Case Officer: Rebekah Morgan

Applicant: Crockwell Farm LLP

Proposal: Reserved matters application to 19/00250/OUT - application for approval of matters reserved by Condition 1 of 19/00250/OUT

NORTH ELEVATION

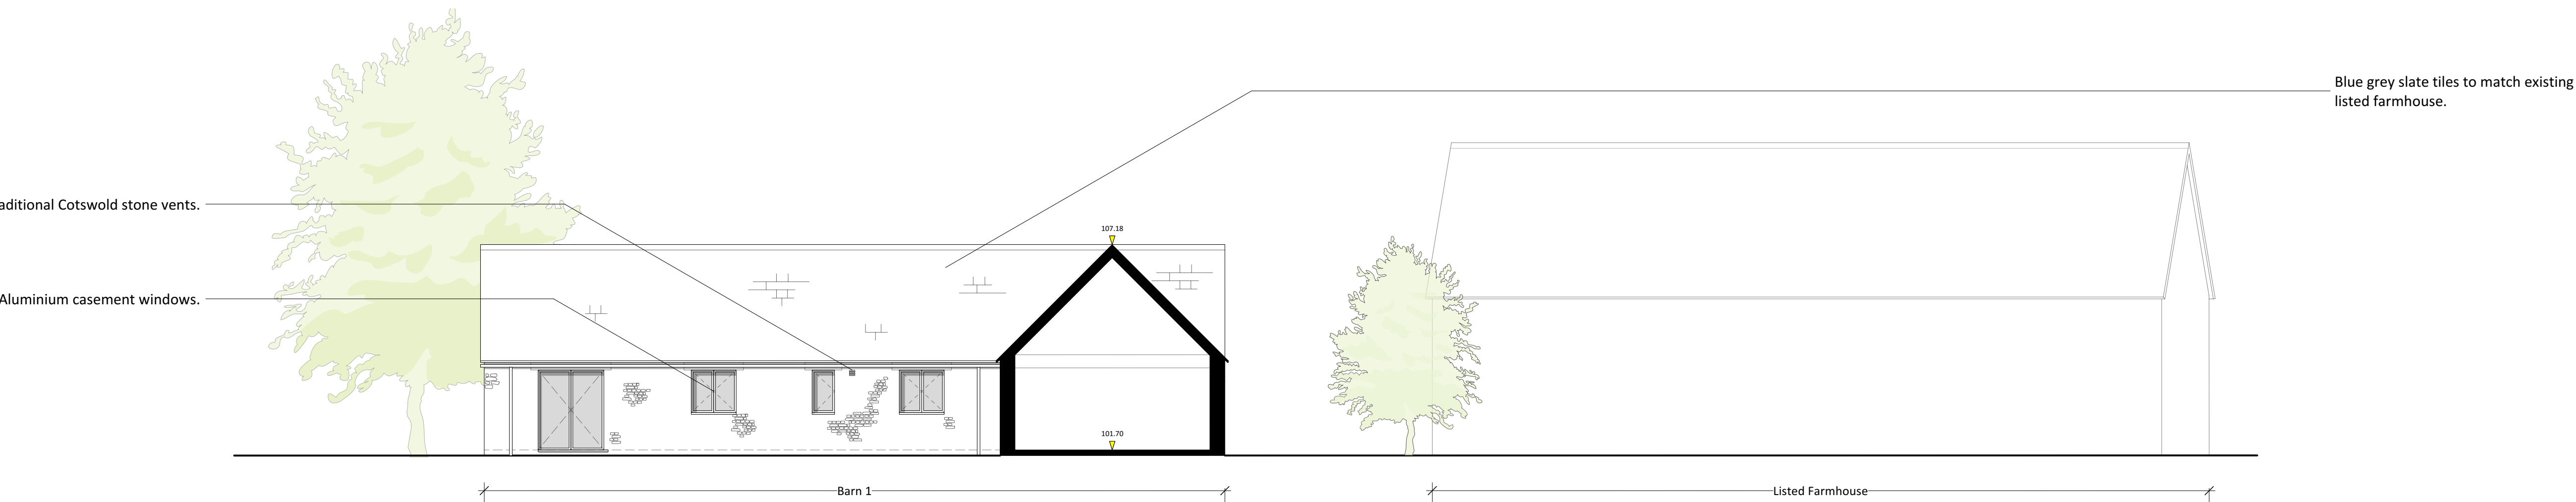
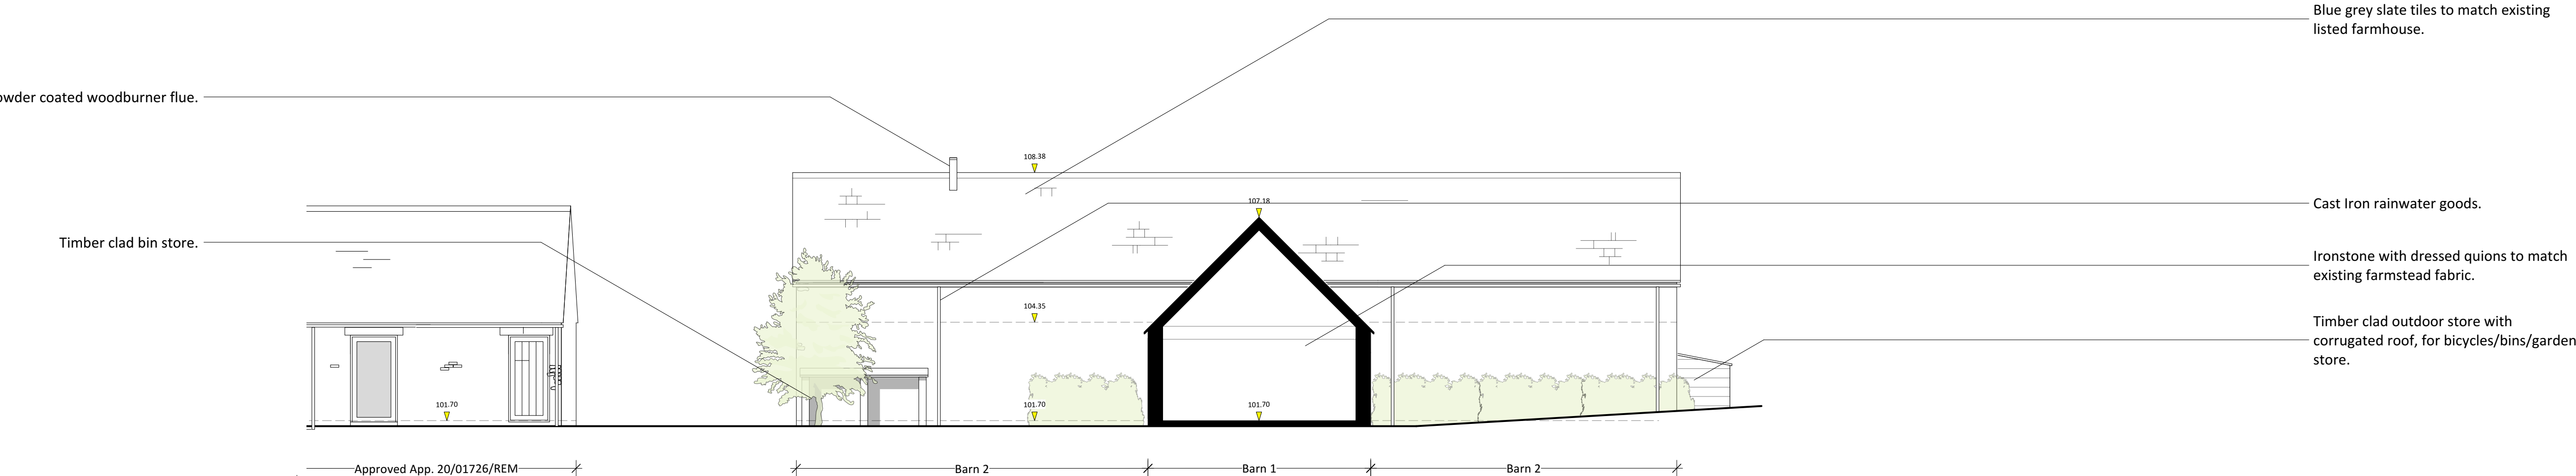
There is always an awkward junction when two ridge tiles meet at the same height, a difference in ridge height helps. They would need to take particular care and we would need to condition the detail.

Gabled stone dormer – the height difference would need to either be more or the triangular gable needs to rise from the eaves as would be more traditional for a gable of this width.

It is a pity about the windows as there would have been scope to articulate the building in a manner more appropriate to a farm, but I do not raise strong objections.

7. Full design details of gabled dormer shall be submitted to and approved in writing by the Local Planning Authority prior to commencement of those works. Thereafter, the development shall be carried out in accordance with the approved details.

8. Notwithstanding the details shown on the approved plans, further details of the architectural detailing of the ridge (including joints), together with the eaves and verge treatment shall be submitted to and approved in writing by the Local Planning Authority prior to the construction of the building above slab level. The development shall thereafter be carried out in accordance with the approved details.
